J.S. THOMPSON
ENGINEERING, INC

May 29, 2020

A site visit was made to 216 Bay Street in Harnett County, North Carolina to inspect the exposed footings at the porch addition.

DESIGN PROFESSIONAL INSPECTION FORM

SHEET 1 OF 3
 S-1
 FOUNDATION PLAN

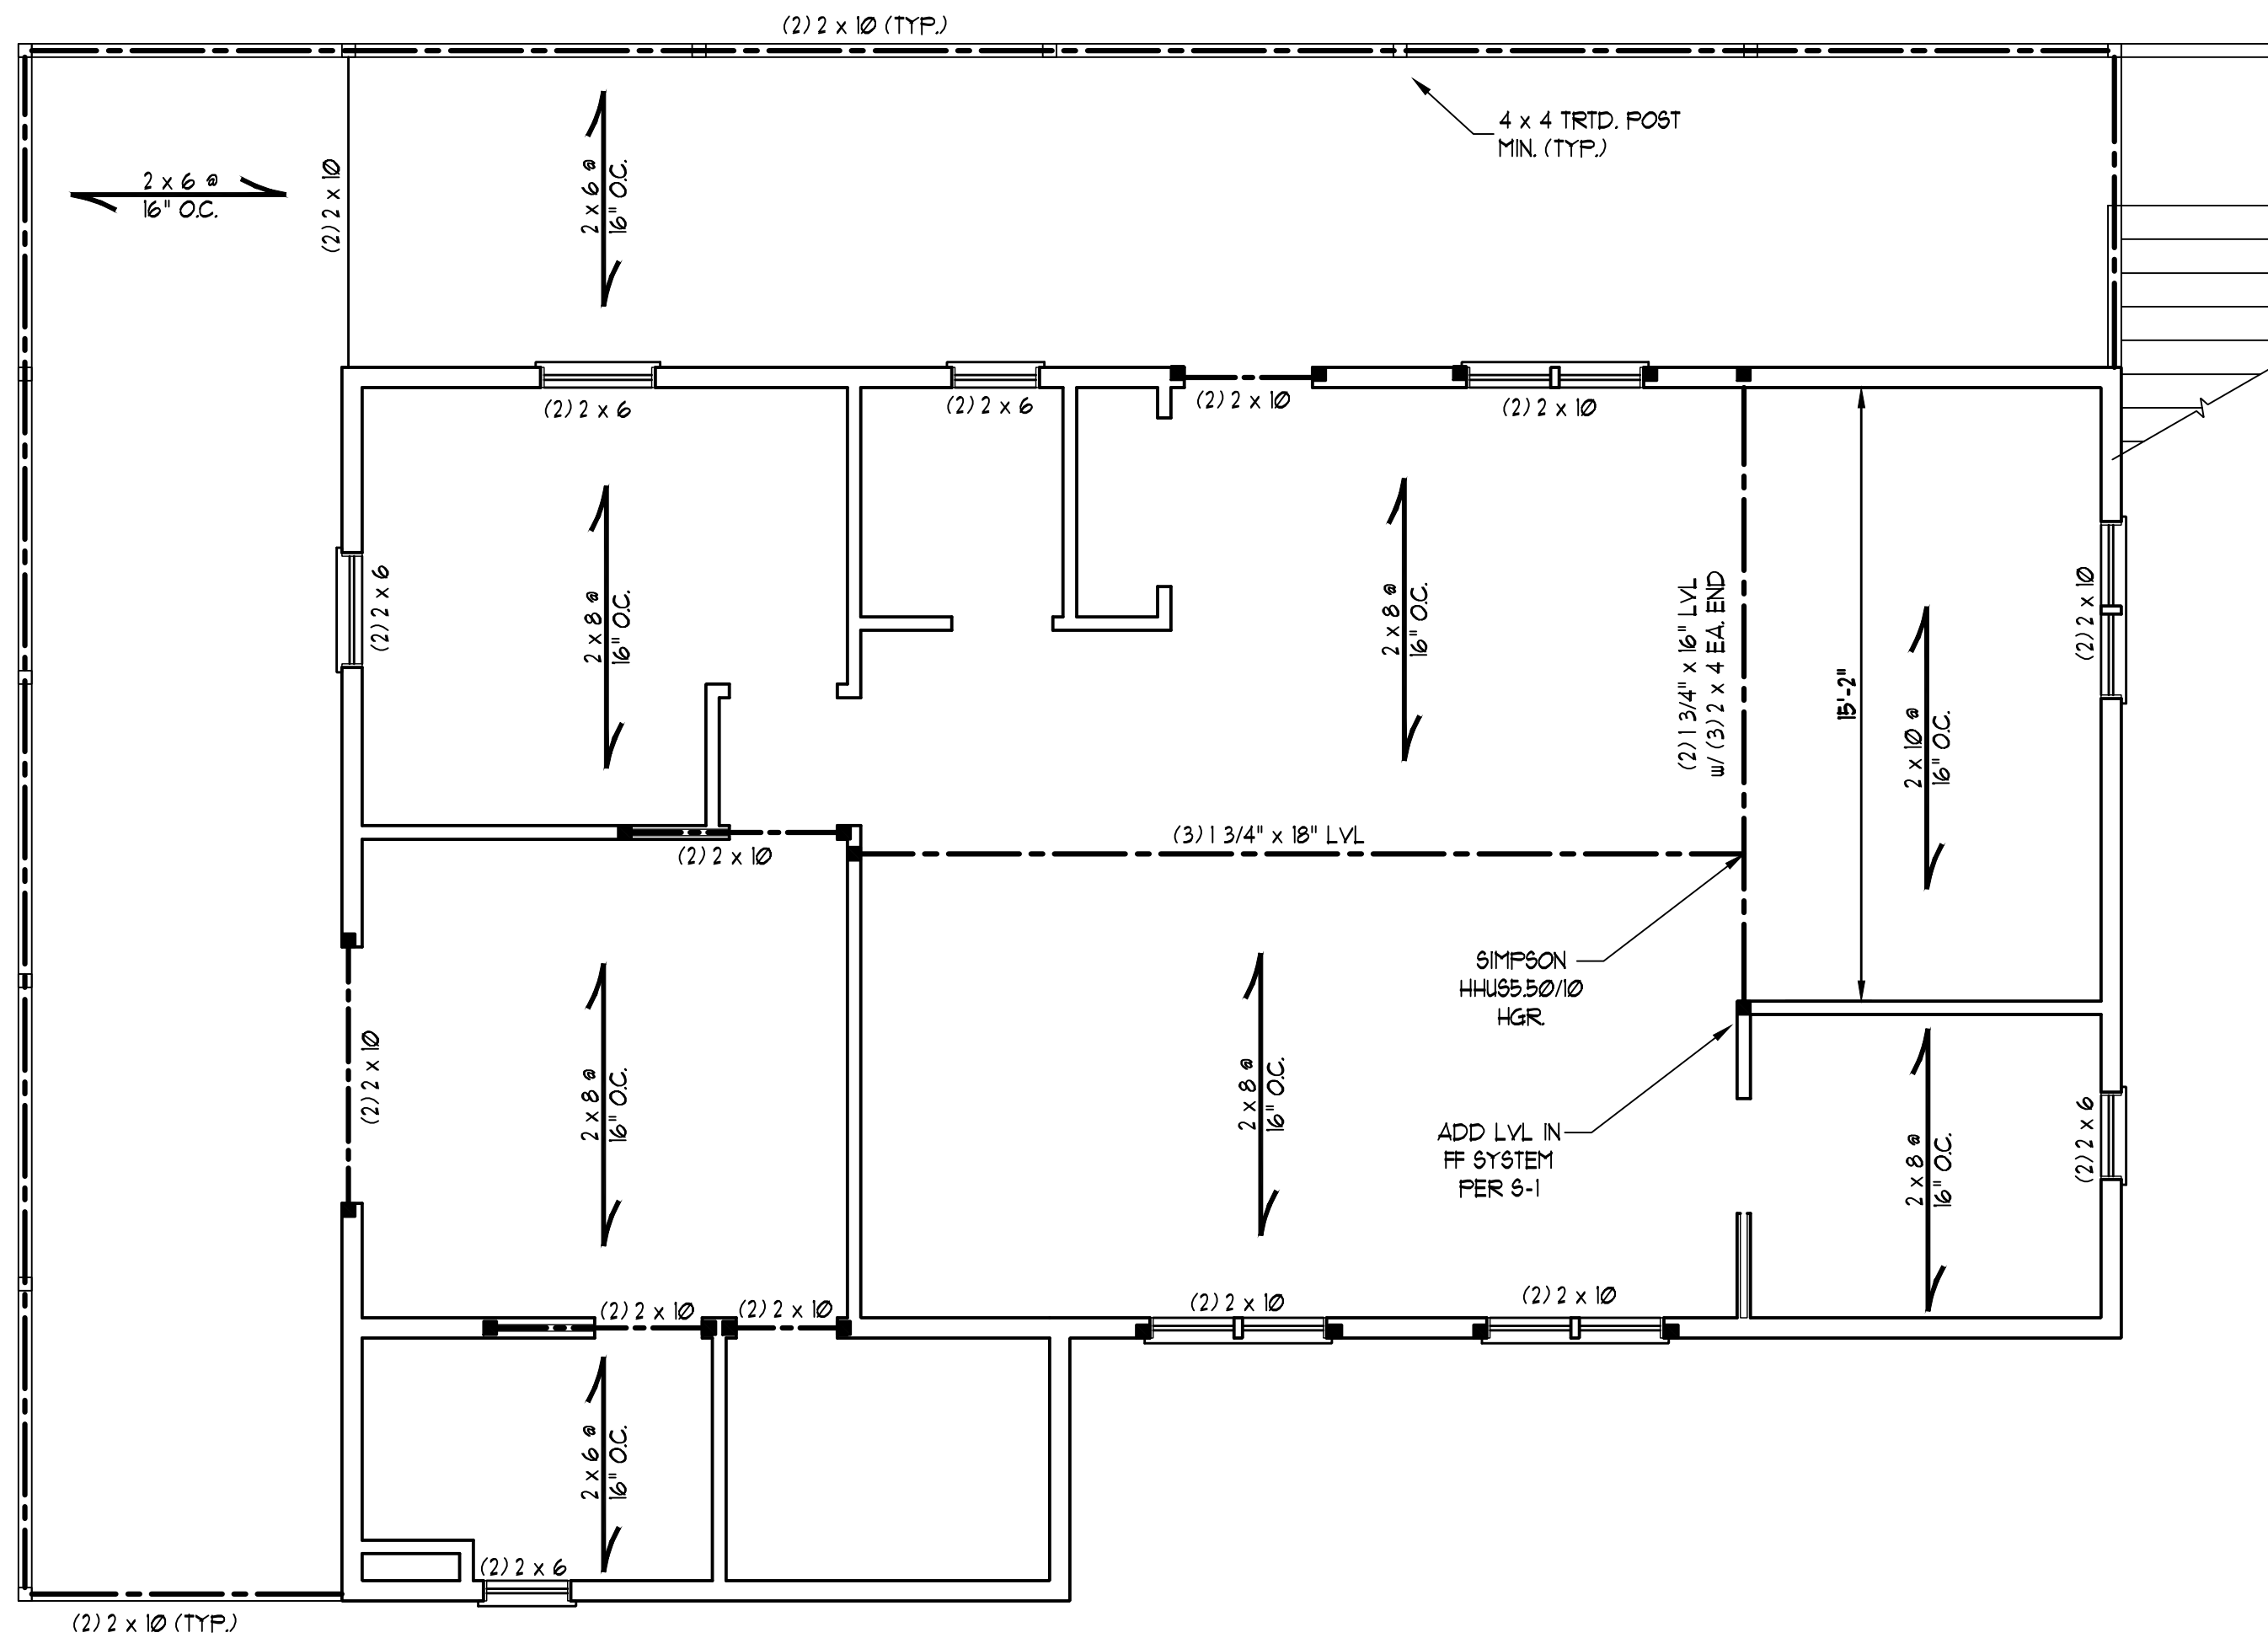
The bottom of the footings was inspected and firm sand was encountered at depths ranging from two to three feet below grade. The soil at the bottom of the footings will provide the minimum required bearing capacity of two thousand pounds per square foot. The footings were excavated per plan with all concrete depths set correctly and are suitable for concrete placement. Holes were excavated adjacent to two existing 8 x 8 treated piles at the existing structure. The piles were verified to have been driven to depths typical for friction piles.

The porch footings lie within the 100-year flood plain and require additional restraint. (3) #4 rebar are to be embedded into the bottom of each 6 x 6 treated post spaced 4" o.c. crisscrossed. The rebar is to extend a minimum of 6" from the face of each post and is to have minimum 3" concrete cover at all sides. 1/2" diameter holes are to be drilled in the posts so that the rebar is snug. The posts are to be set on the poured footings and an additional 16" of concrete is to be poured on top to encase the bottom of the posts.
